SUBJECT: Engineering Review Comment
Mountain View Electric Association Inc. (MVEA)

Project Name: Sterling Ranch Filing No. 5 – Final Plat

Project Number: SF241

Description: Proposed development of 72 residential lots located in the northwest corner of Sterling Ranch Rd. and Dines Blvd. in Township 12S, Range 65W, Section 33.

STERLING RANCH FILING NO. 5

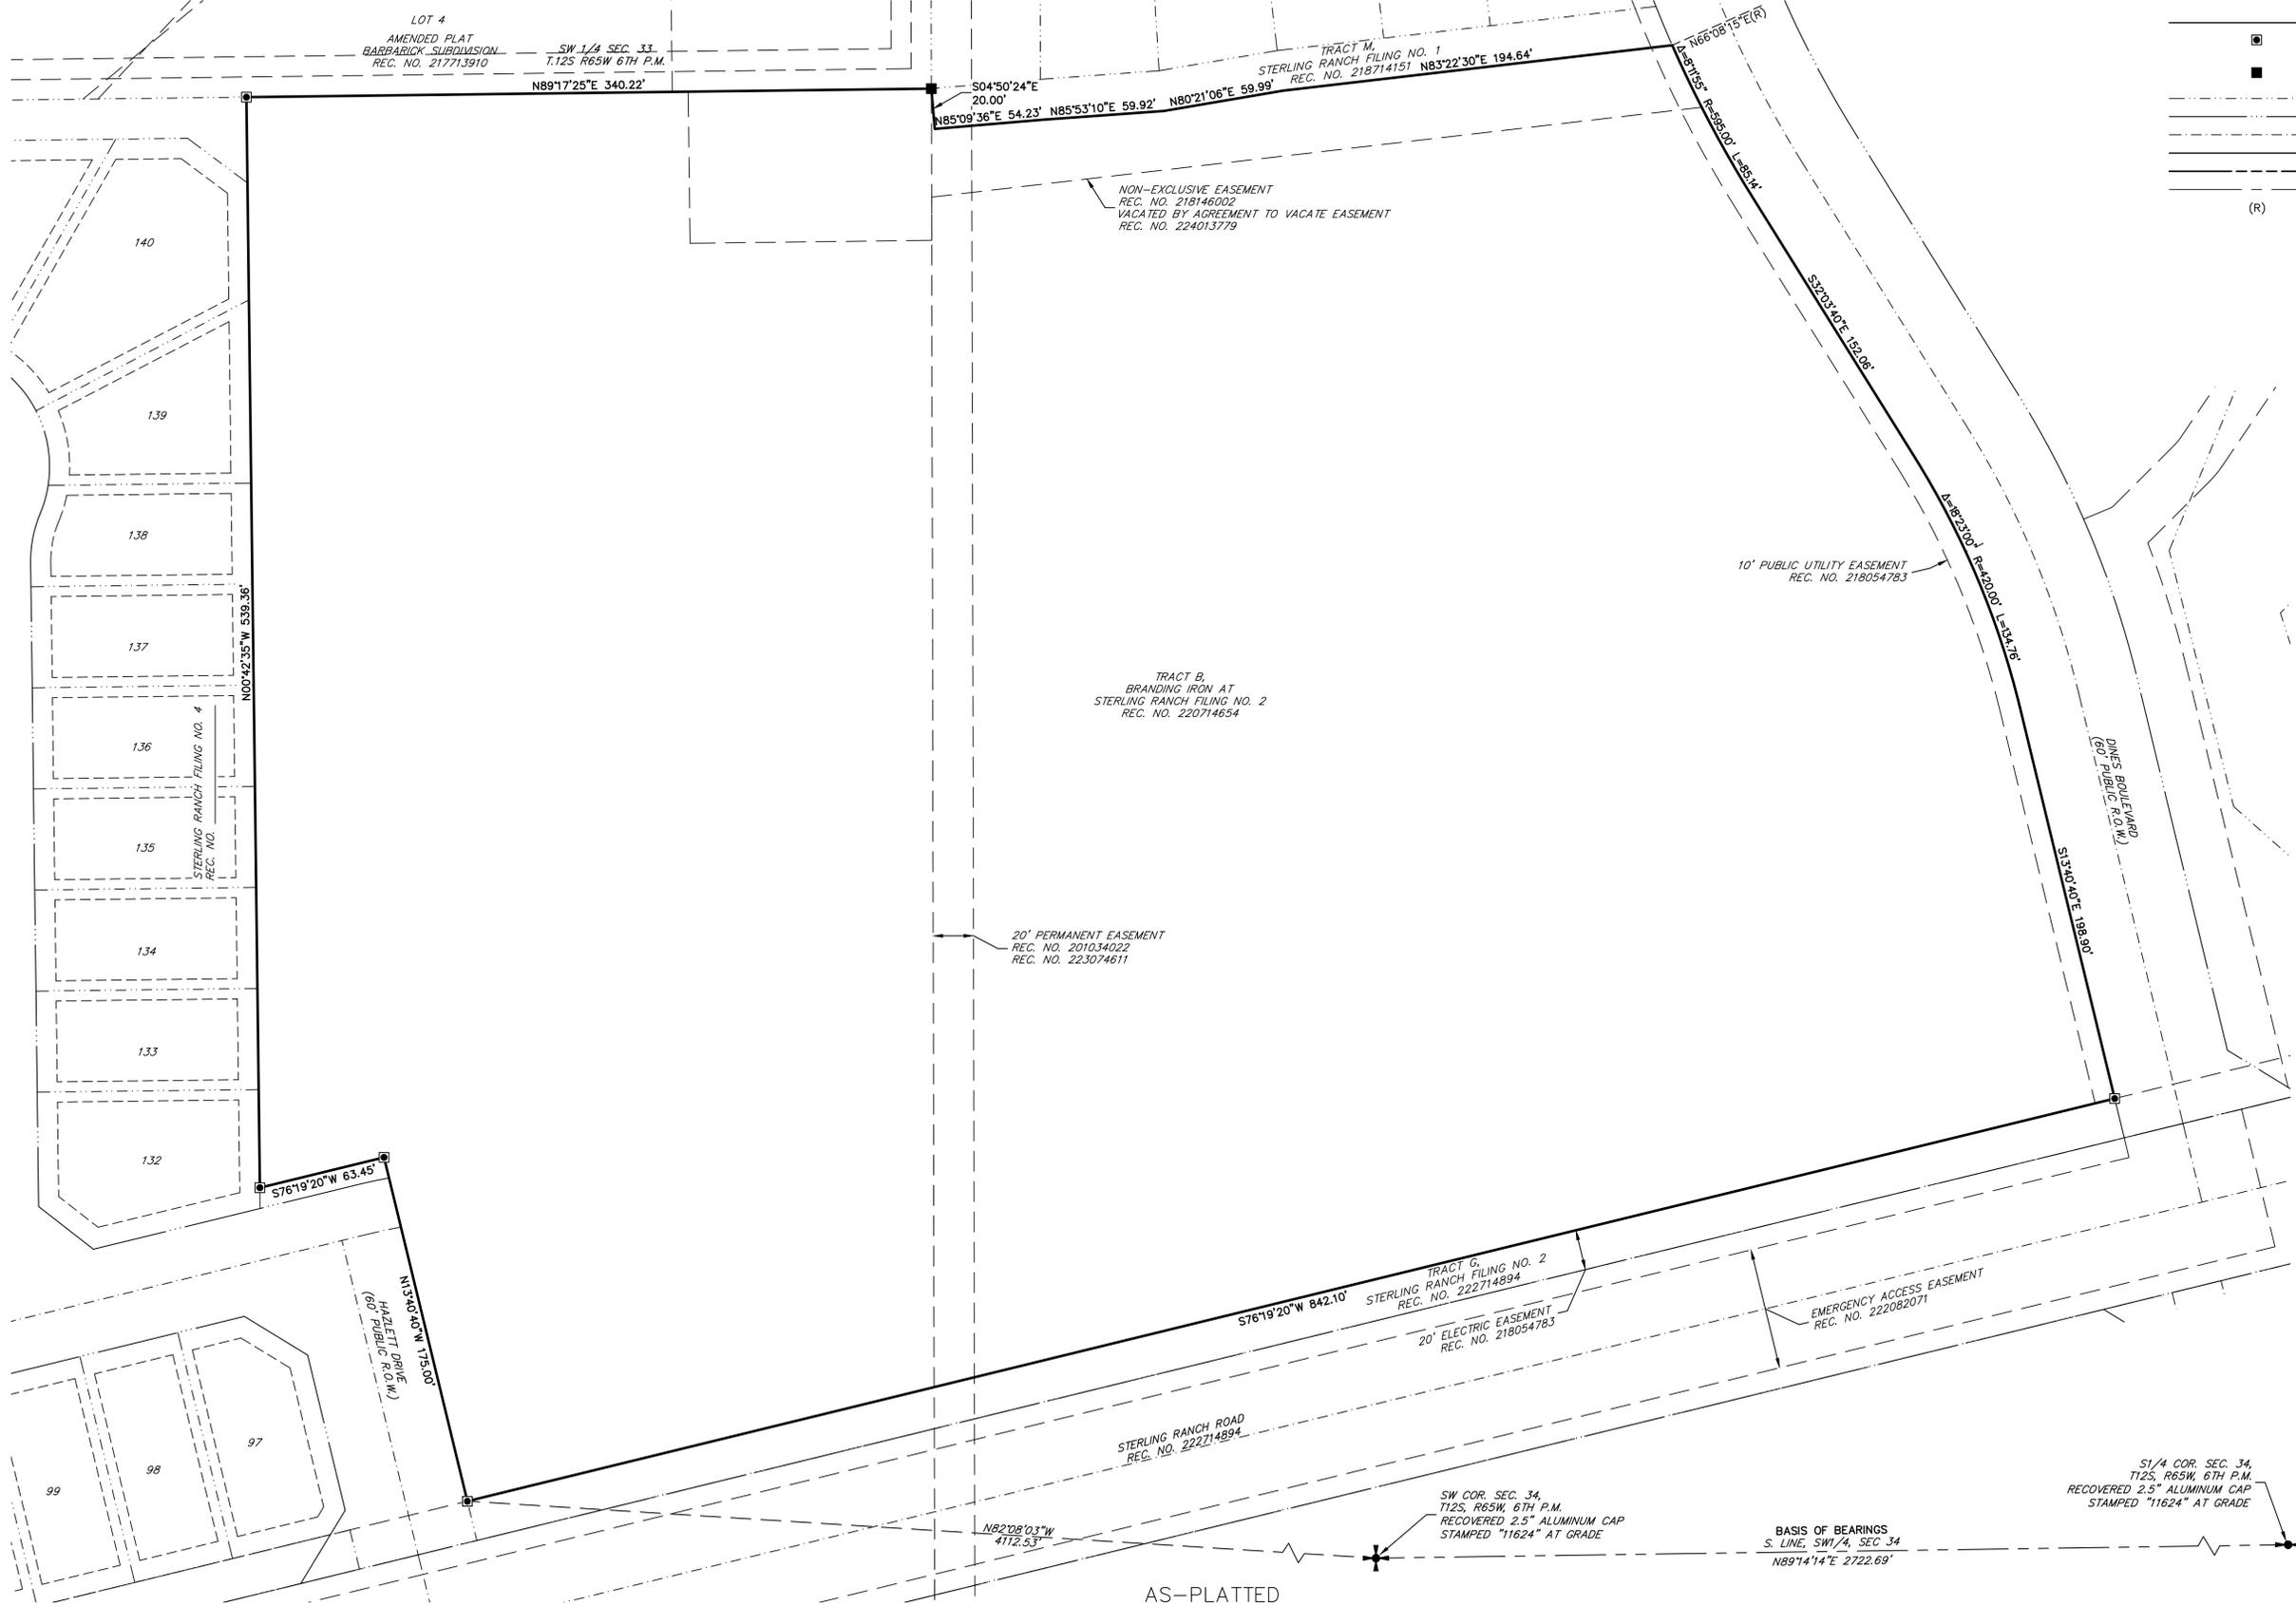
MVEA requests a ten (10) foot front lot utility easement, in addition to any public improvement easement, a five (5) foot side lot utility easement, and a ten (10) foot rear lot utility easement along with a twenty (20) foot exterior utility easement on the plat and all tracts include easements. MVEA also requests the platting of MVEA's existing facilities with easements on the plat. Additional easements may be required.
